February 18, 2015

Project Name: Eyecare Medical Group- Parking Expansion      Project ID: 2014-221  
Address: 53 Sewall Street      CBL: 190 H024 001  
Applicant: Eyecare Medical Group- Terry Wogan  
Planner: Shukria Wiar

On February 18, 2015, the Planning Authority approved with conditions a Level I: Site Alteration site plan for the proposed parking lot expansion located at 53 Sewall Street. The project includes the construction of a twenty-tree (23) spaces surface parking lot and an underdrained soil filter. The project will create 5,526 SF of new pavement surface.

**UDSF OVERFLOW/FOREBAY SPILLWAY CROSS-SECTION**  
NOT TO SCALE

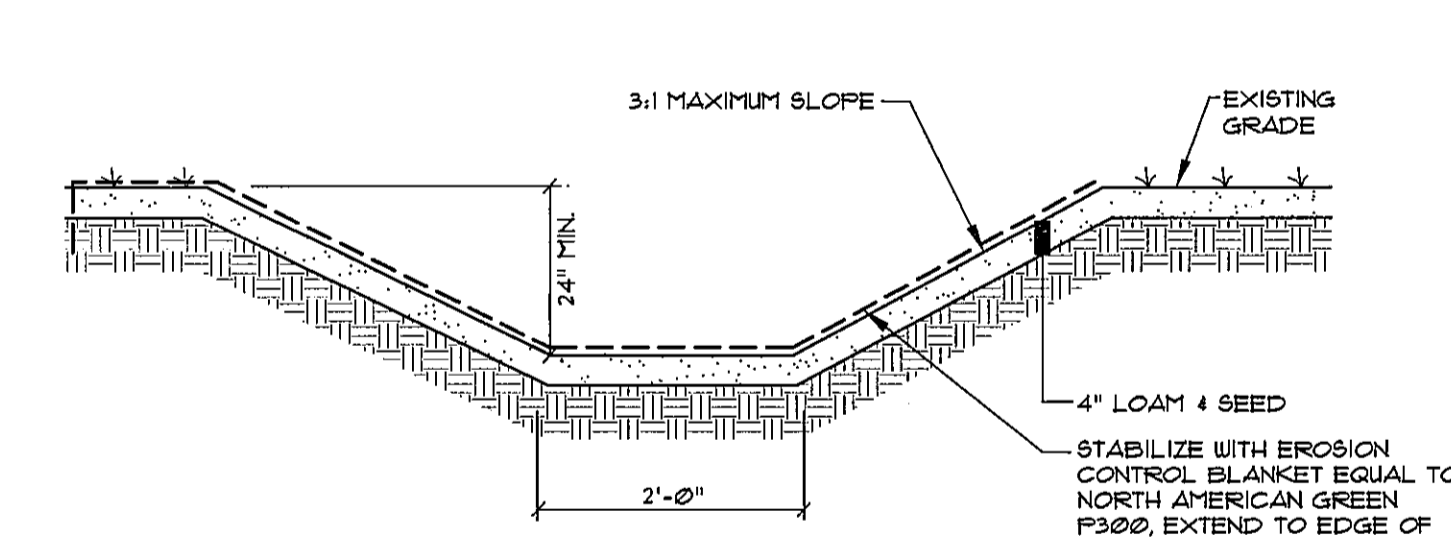
3. Plan Sheet 4 of 5 – The *UDSF Overflow / Forebay Spillway Detail* incorrectly lists the overflow spillway elevation as elevation 31.40; the overflow spillway elevation should be 30.90 per plan. The final plan set shall show this correction.
